7 Individual Community Submissions

7.1 Communication

Figure 6.11 Cherrybrook Station - Indicative layout

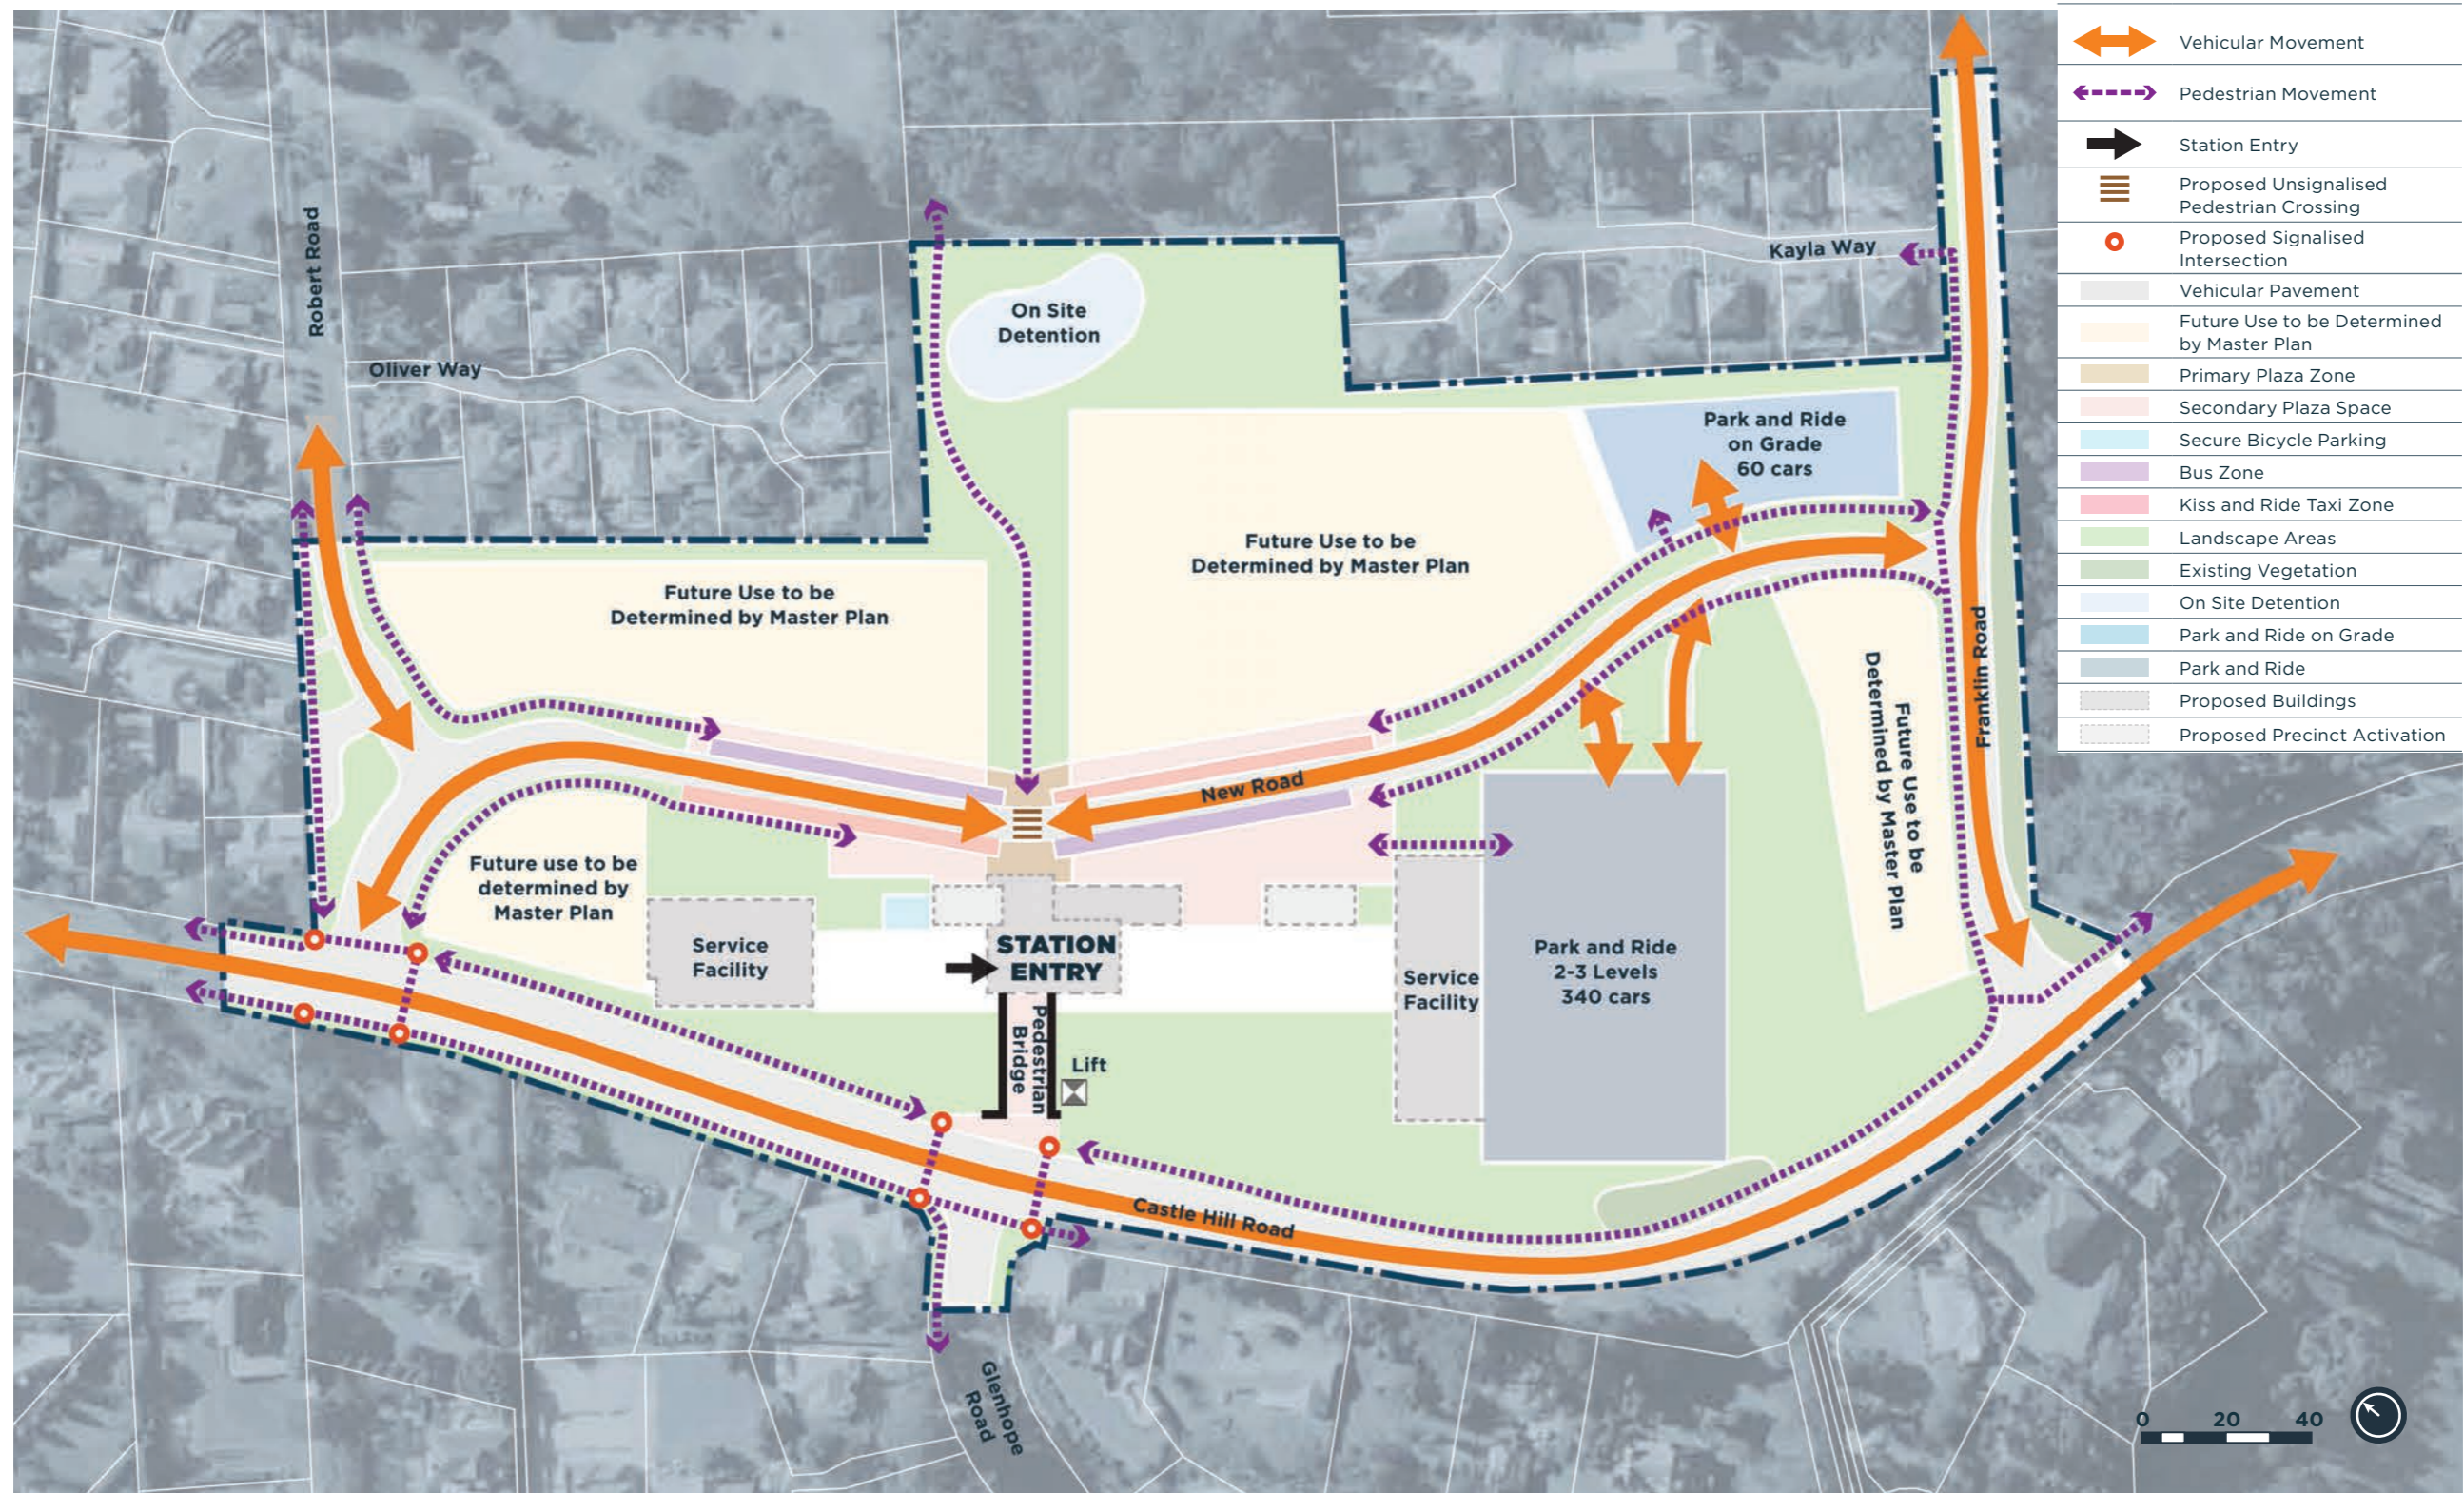
- d.** Consultation with Kayla Way residents was inadequate during the preparation of the design of the station precinct and access to the station. There has been no consultation held with residents of Kayla Way regarding the placement of a car park and the plan to use Franklin Road and Robert Road as access roads to the station.

- z.** Justifications given by NWRL at community information sessions for the need to use John Road and Robert Road to access Cherrybrook Station have been implausible and were based on erroneous information.

As a result of community feedback received, changes have been made to the design of the Cherrybrook Station precinct to improve access and reduce potential impacts on local residents. The reconfigured design features improved access and safety for neighbouring residents, with landscaping proposed to screen properties from headlight glare. This new design will produce a better outcome for residents in conjunction with improved access to Cherrybrook Station.
